Subject: M 14-D8

Re: Waterman Inc. Grading and Drainage Plan

RE: WATERMAN INC. (M14-D8) RECEIVED JULY 19, 1984

RE: DRAINAGE PLAN FOR LANDS OF BROADWAY DEVELOPMENT COMPANY
(M-14/D8A) RECEIVED JULY 18, 1989

GRADING & DRAINAGE PLAN  
WATERMAN, INC.

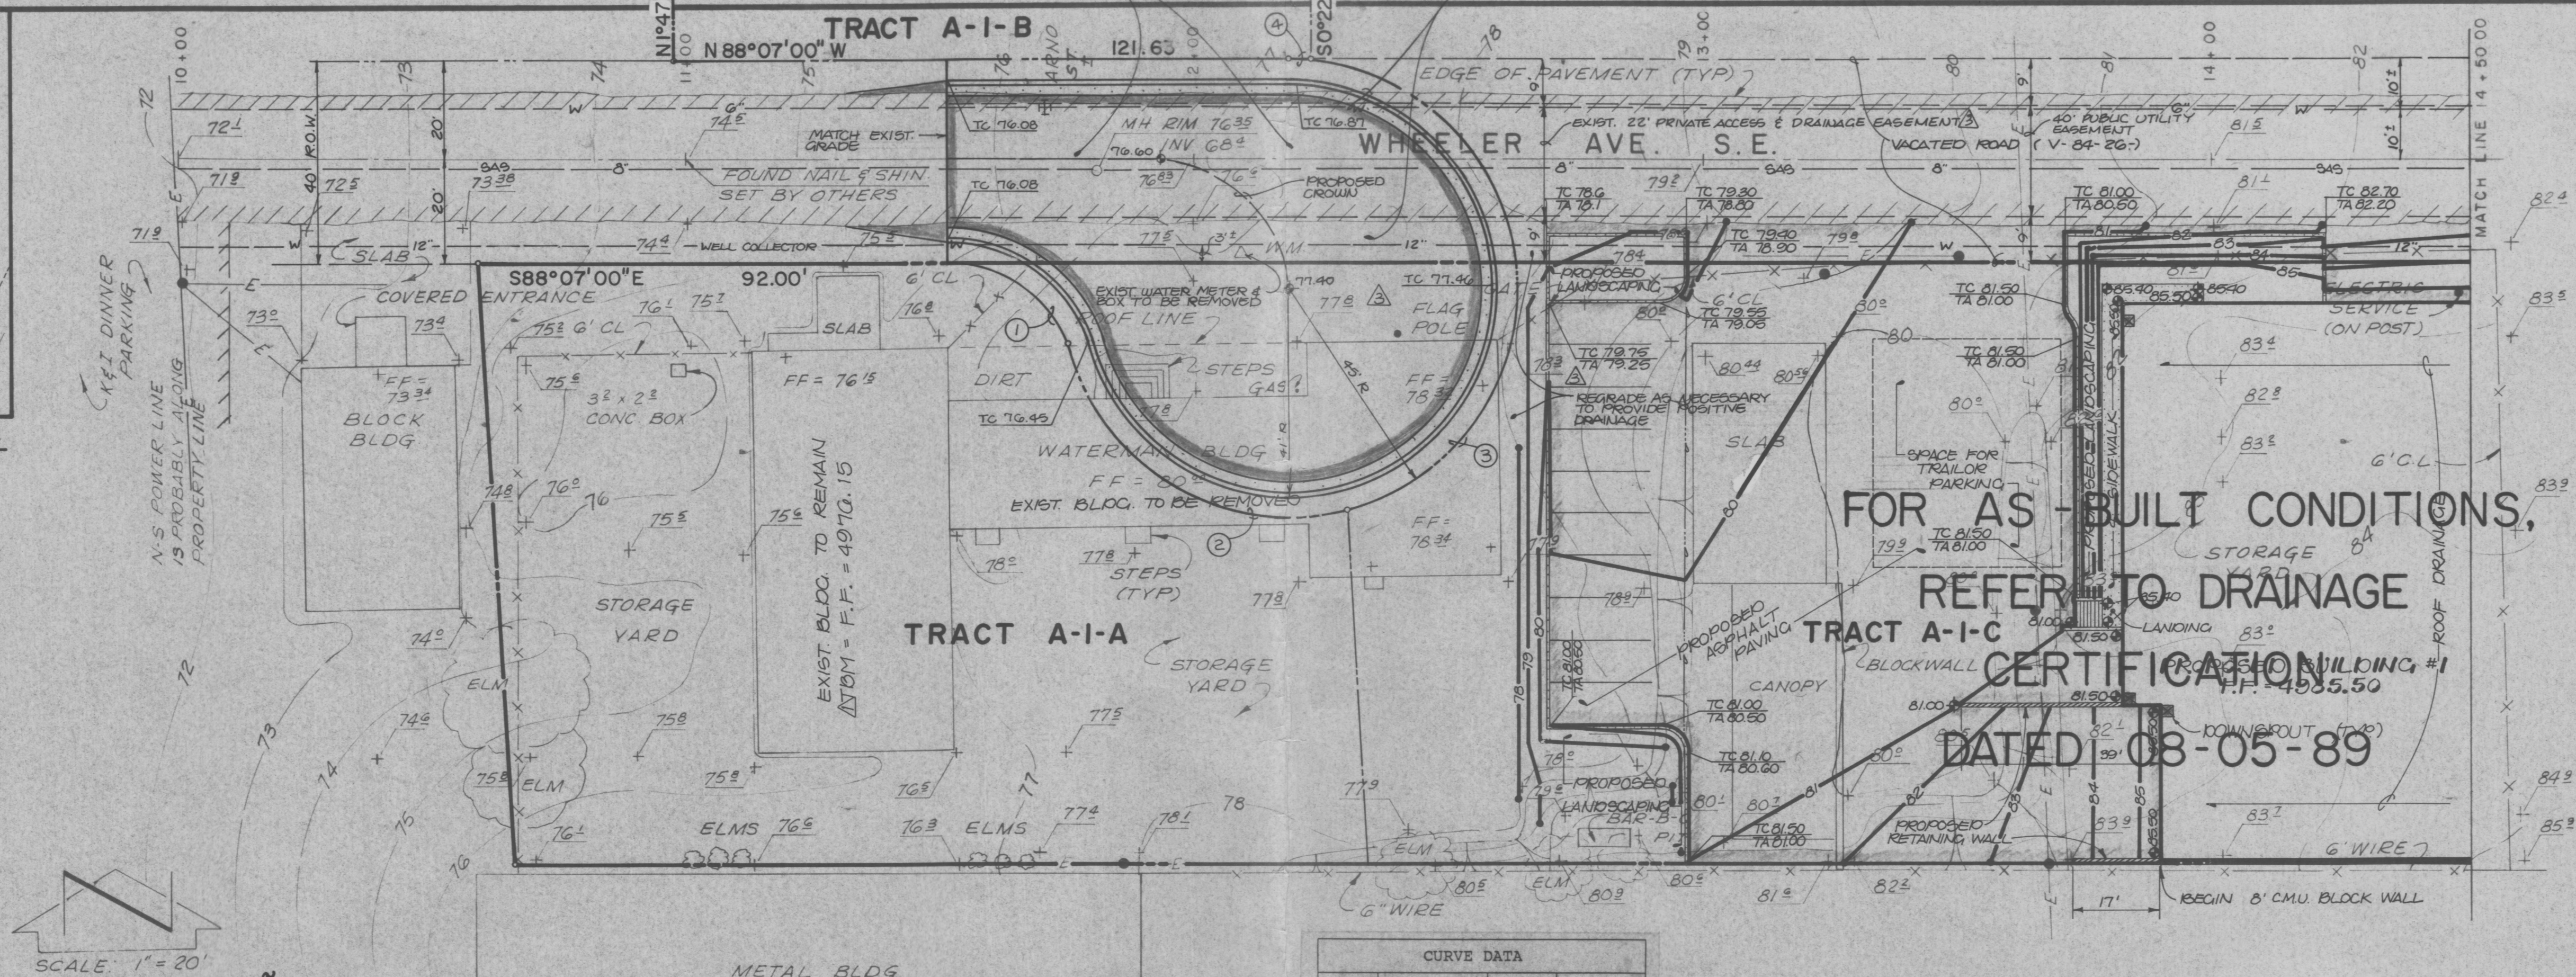
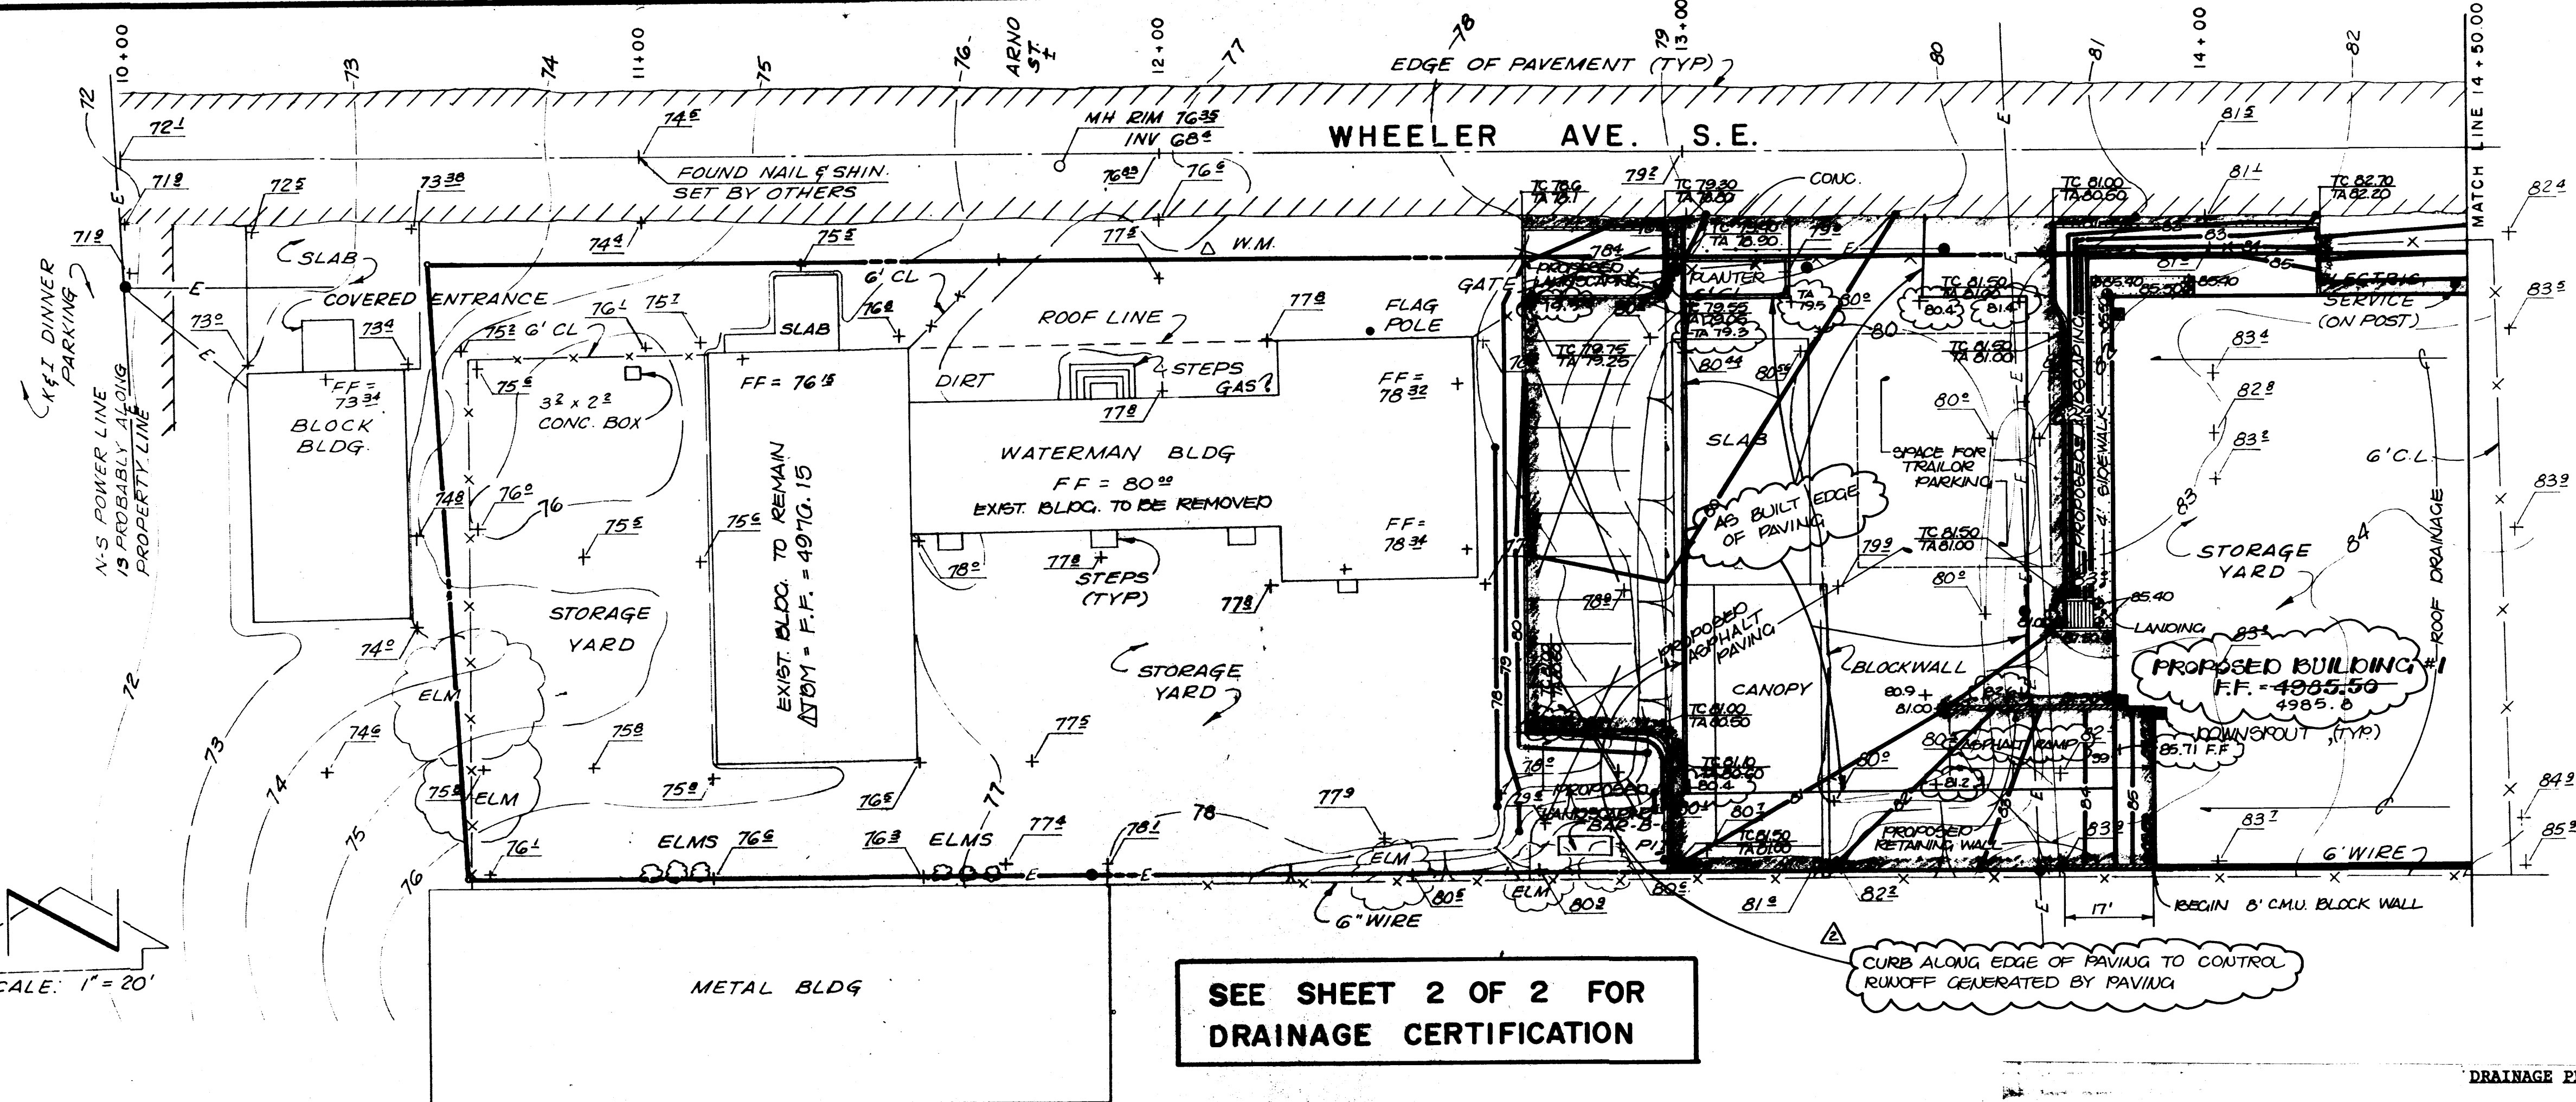
1. How will the traffic from Tract A-1-C and the other adjoining tracts exit onto the proposed cul-de-sac? Your submittal indicates no drive pad into the cul-de-sac.
2. Please advise your clients that there is an outstanding Certificate of Occupancy matter that still exists.
3. On April 26, 1988, your request for Certificate of Occupancy was denied because the site was not in compliance with the approved drainage plan.

1. Curb and gutter for the proposed cul-de-sac will be mountable roll type. This will allow traffic to enter onto the adjoining tracts and will also eliminate the need for drivepads.
2. Based on a site visit, the curb has been constructed along the edge of the pavement. Attached is the Drainage Certification update.
